**re:** **Grading and Site Servicing Plans Review**  
**Proposed Residential Development**  
222 Baseline Road – Ottawa, Ontario

**date:** October 20, 2025

**file:** PG6324-MEMO.01

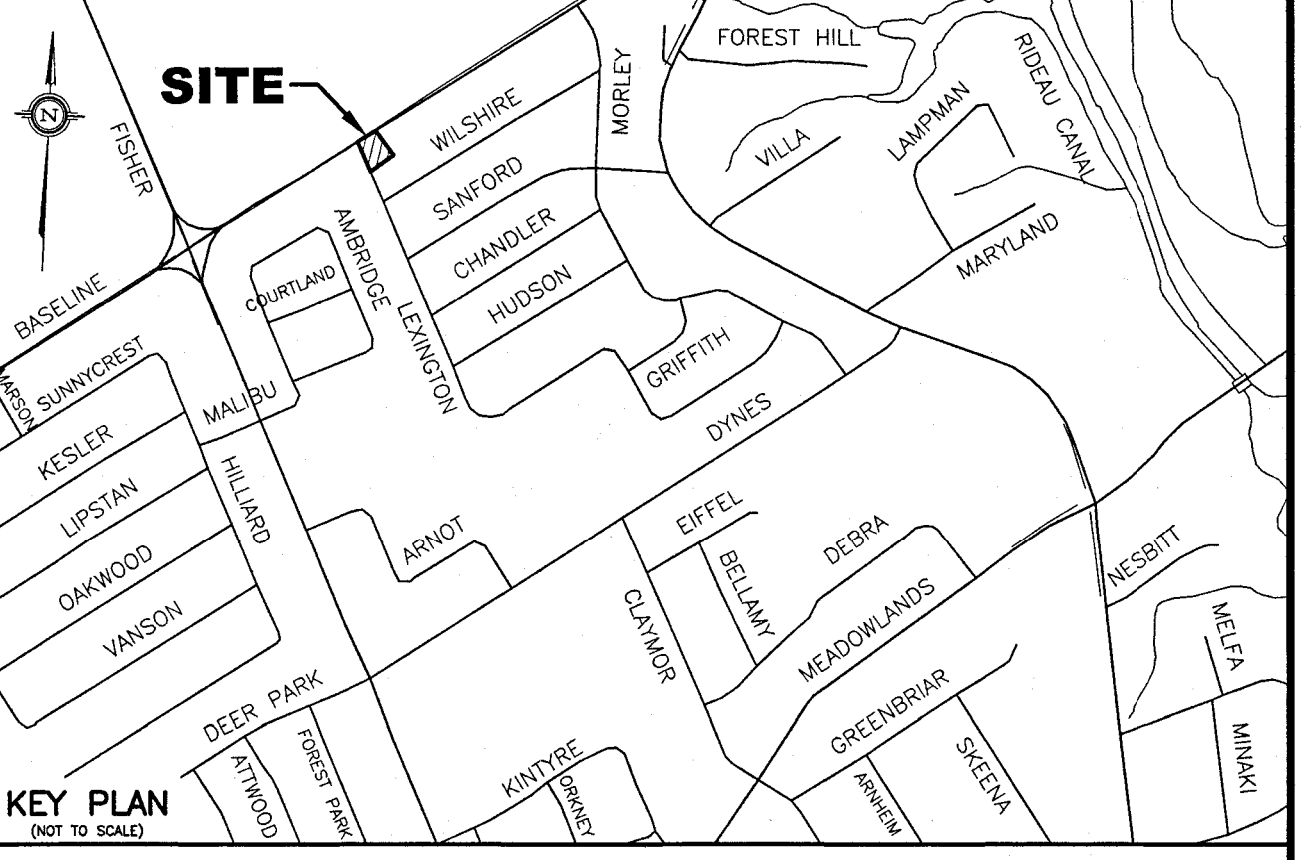
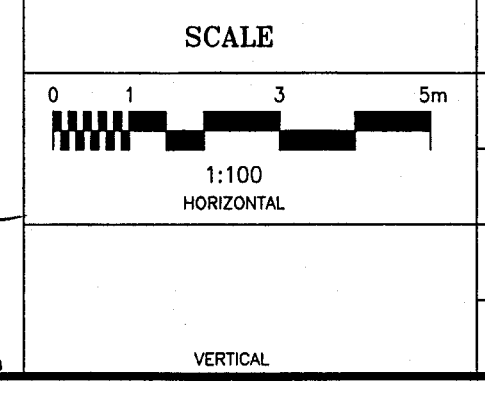
Based on our review of the grading plans, it is expected that the proposed underside of footing (USF) elevation is 80.15 m. Upon reviewing the subsurface profile according to the completed boreholes, the footings are set to be founded over an existing fill layer. This bearing medium is not acceptable to provide sufficient bearing capacity as per the above-noted geotechnical report. Therefore, it is recommended that the footings be dropped to a maximum elevation of 79.3 m. Alternatively, the footings may be founded over concrete in-filled, vertical, zero-entry trenches, extended vertically to an elevation of 79.3 m, or deeper.

If the USF is kept as per the grading plans, a bearing resistance value of 75 kPa (SLS) and 125 kPa (ULS) should be utilized for the proposed footings. These values will be required to be verified in the field. If the fill is found to be in a loose state of compactness, proof-rolling of the subgrade will be required. If organic matter is found within the fill material, or if soft spots develop, these areas will be required to be removed and replaced with OPSS Granular A or B Type II engineered fill. If required, the engineered fill should be placed in maximum 300 mm thick loose lifts and compacted to a minimum of 98% of the material's standard Proctor maximum dry density (SPMDD). Furthermore, frost protection will be required to be implemented as per the recommendations provided in the following Subsection 1.3

Based on our review of above noted grading plan, the perimeter footings for the proposed development are not provided with sufficient soil cover for frost protection. Therefore, rigid insulation will be required. Reference should be made to Figure 1 – Insufficient Soil Cover (Footings), attached to the current memorandum.

Insufficient frost protection has been provided for some of the proposed sanitary and storm sewer pipes throughout the subject site. Reference should be made to Figure 2 – Insufficient Soil Cover (Services), attached to the memorandum.

**It should be noted that the invert elevation of the watermain pipes has not been presented in the above-noted site servicing drawings. Therefore, if insufficient soil cover is provided for watermain pipes, rigid insulation should be installed for the proposed watermain pipes as recommended in the above table (Table 2).**

The trenches should extend horizontally to a minimum of 300 mm beyond the edges of the proposed footings in all directions. The concrete should consist of 20 MPa lean-mix (28-day strength). The side walls of the trenches can be used as forms in preparations of concrete placement.

To accommodate insufficient soil cover for the proposed footings, rigid insulation is required to achieve adequate frost protection. Rigid insulation recommendations are presented in Table 1 on the following page.

To accommodate insufficient soil cover for the proposed footings, rigid insulation is required to achieve adequate frost protection. Rigid insulation recommendations are presented in Table 2 on the following page.
